THE COMMONS AT FALCON FIELD
PRELIMINARY PLAN

12445 RIO LANE, AND VACANT LAND
 PEYTON, EL PASO COUNTY, COLORADO

ISSUE	DATE
INITIAL ISSUE	3/16/23
RESUBMITTAL	4/10/24

SP1

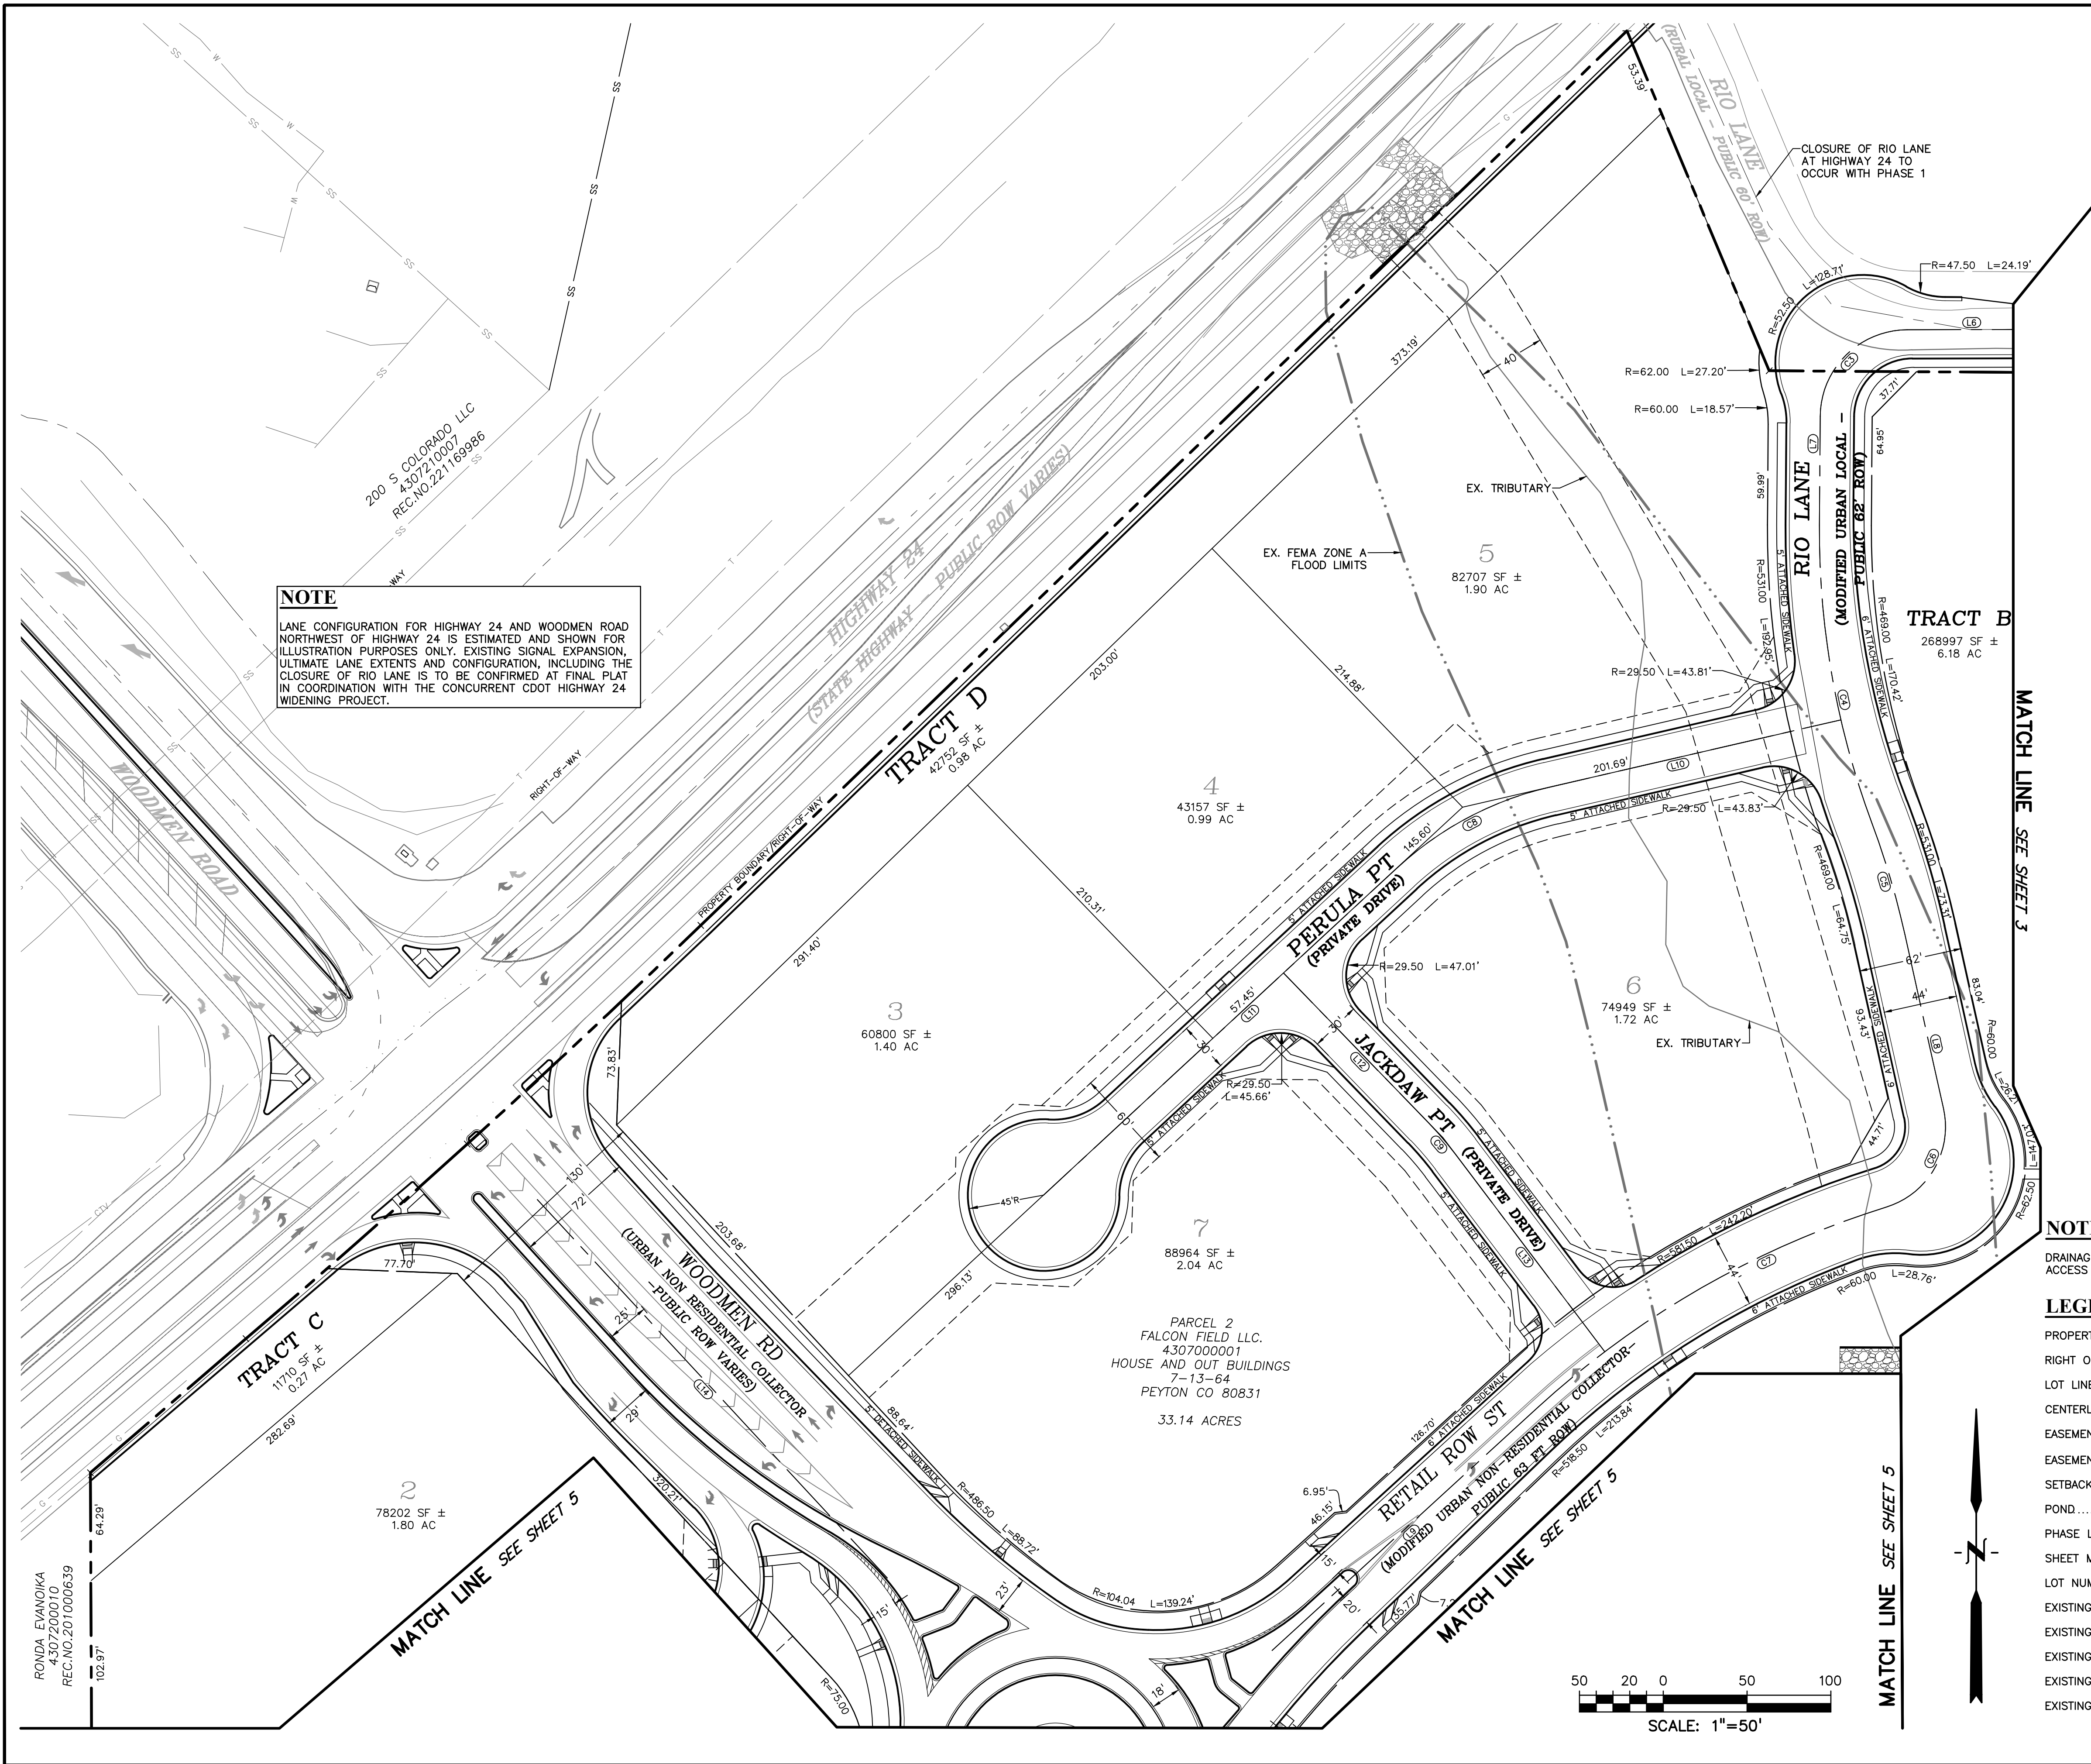
review 3 comment: Per ECM 2.5.6 G Corner islands separating right turns shall be provided at all high capacity intersections.
 Also per ECM 2.5.2.F Pedestrian refuge area is required for crossings longer than 48'
 review 4: Provide pedestrian refuge area per ECM 2.5.2.F

provide bike path for westbound and southbound movement

provide min. 10 ft sidewalk at bike path

Remove this part of the lot line, as it appears to extend into public row

please provide a separate easement for the channel that is to be maintained by the County. It shall be a non exclusive permanent easement similar to the one for the box culvert. The easement shall encompass the channel and the maintenance access on each side.

SP3

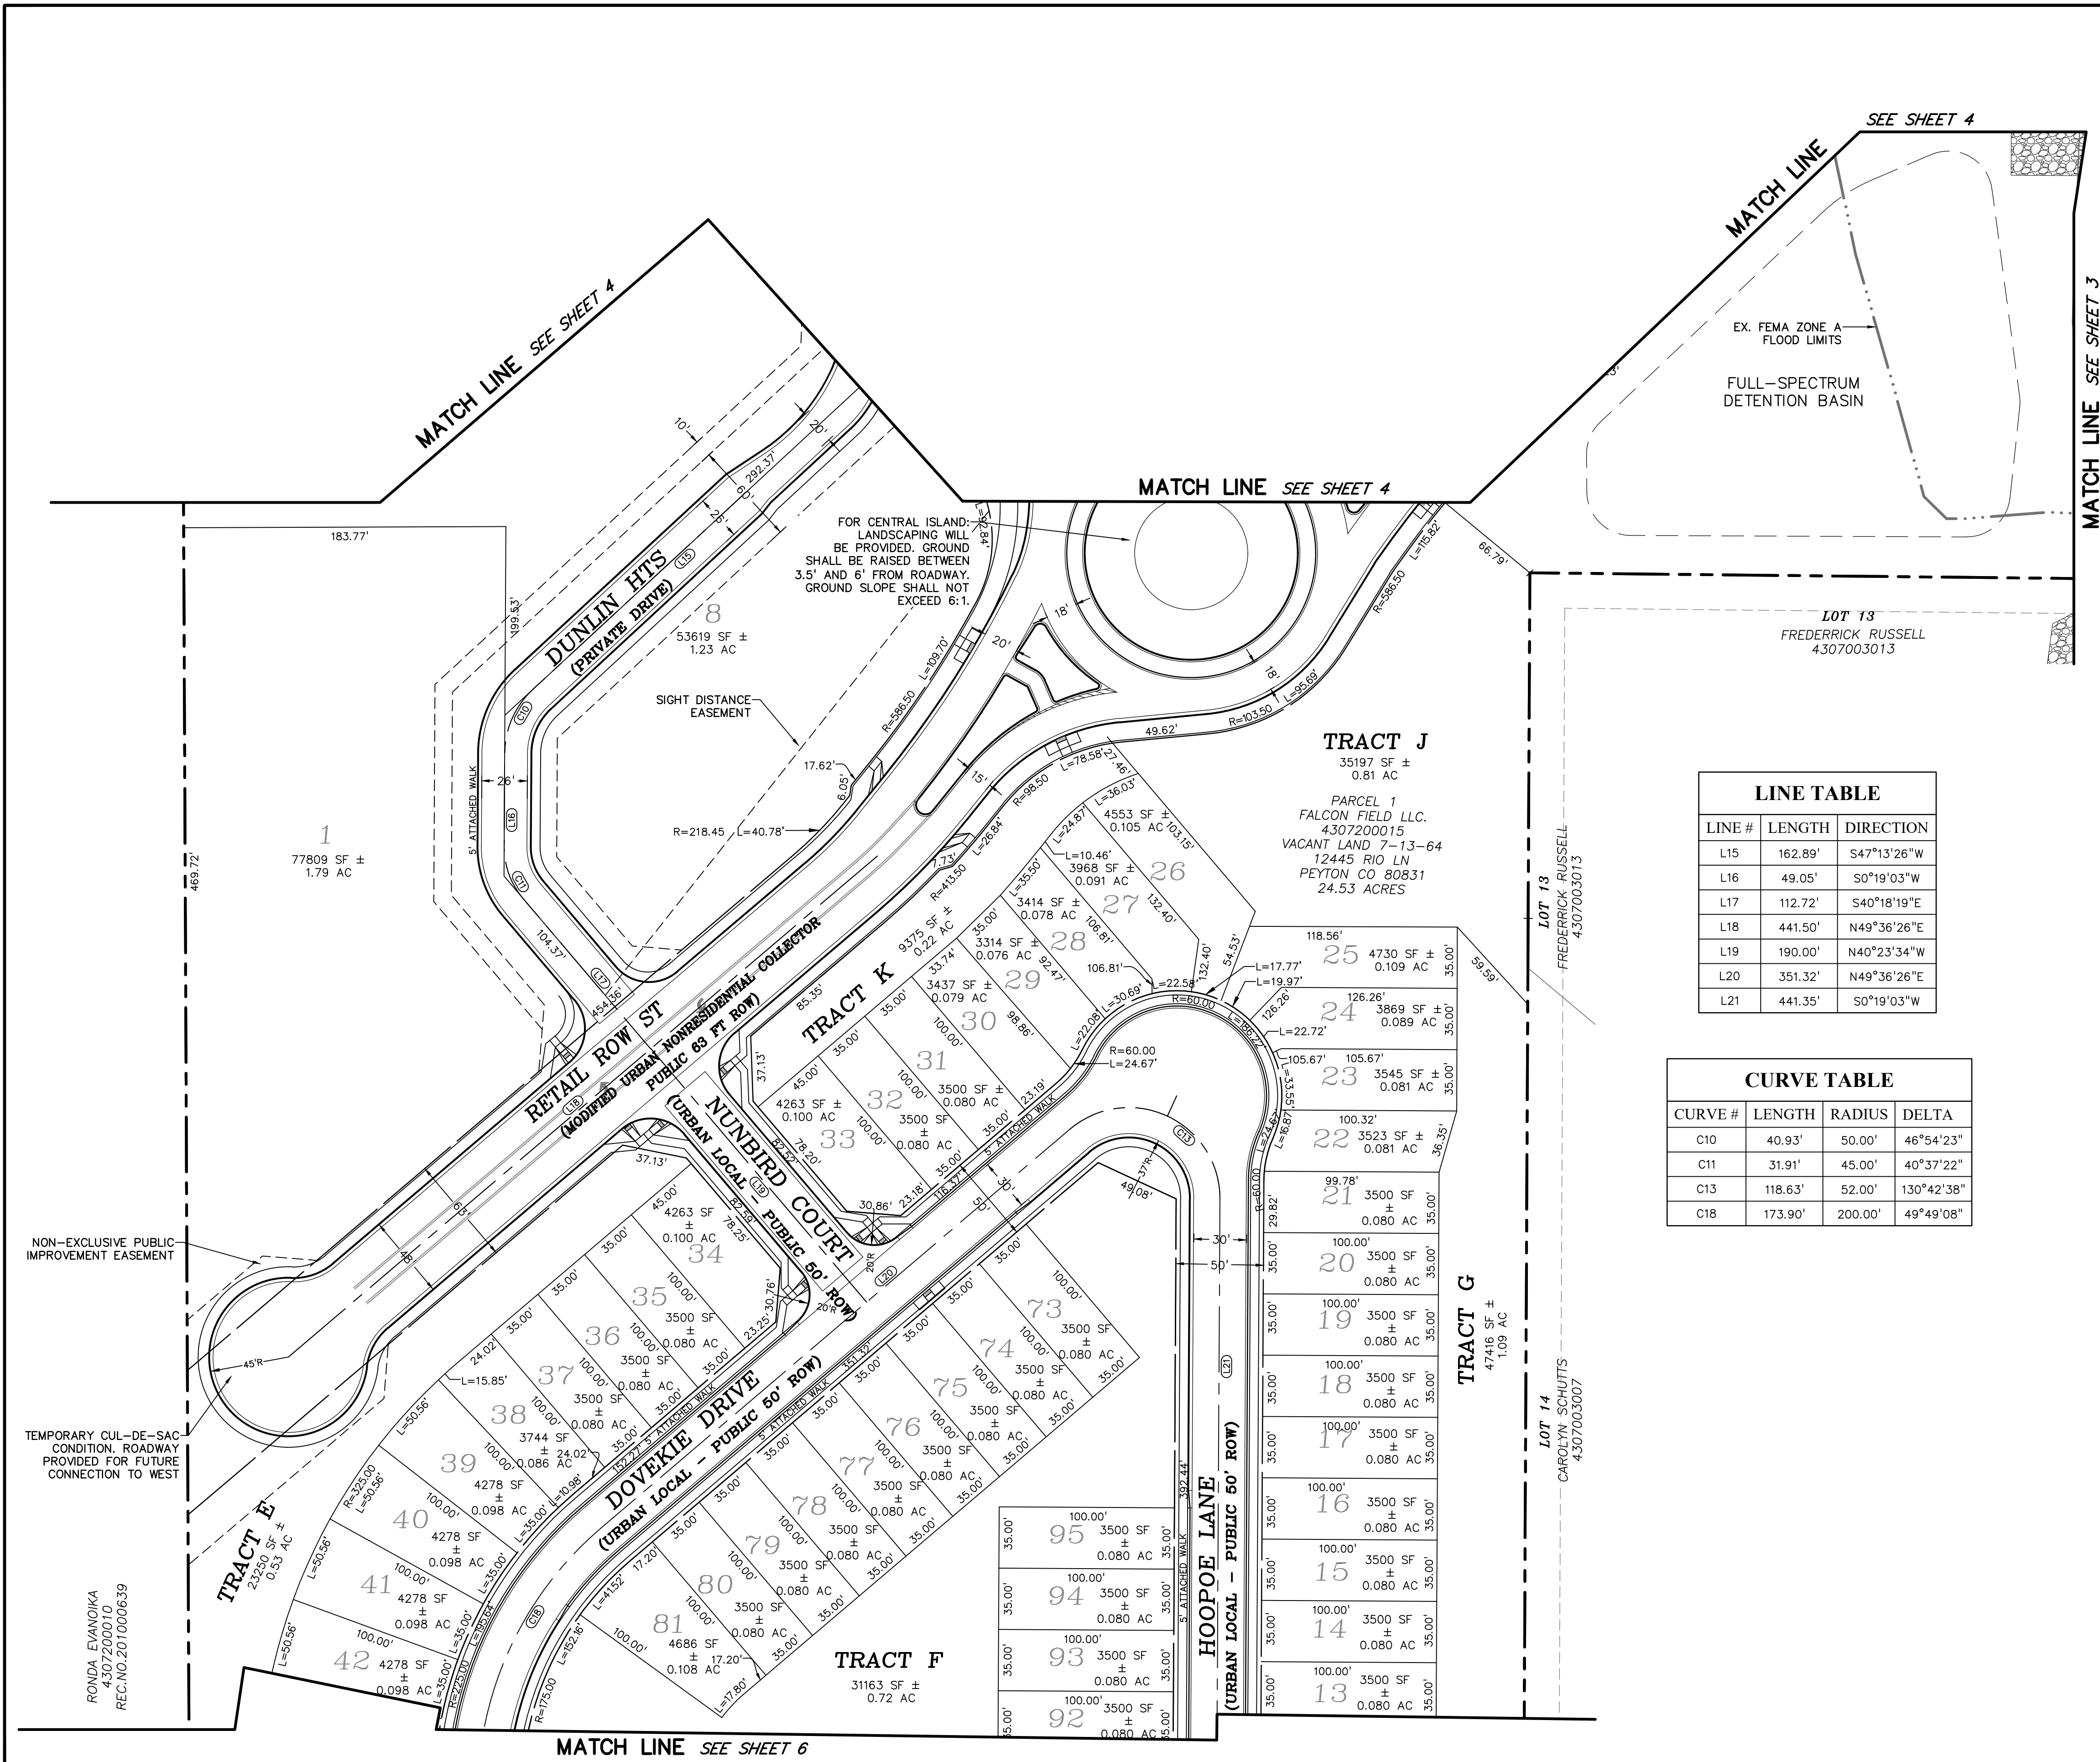
Review C2: provide temporary cul-de-sac if access to lot 77 will be provided from this section of roadway. A non-exclusive public improvement easement will be required. Refer to ECM 2.3.8.C.1.
Review C3: Unresolved.
Review C4: Please identify a non-exclusive public improvement easement for the portions of the cul-de-sac outside of the ROW, refer to ECM 2.3.8.C.1

Dunlin Hts should be located in an easement, like the private drives on pg. 4.
Review C2: provide site distance easement, coordinate with the traffic engineer.
Review C3: Unresolved.
Review 4: Unresolved. Please provide sight distance easement

provide min. 10 ft sidewalk at bike path

provide bike path for westbound movement
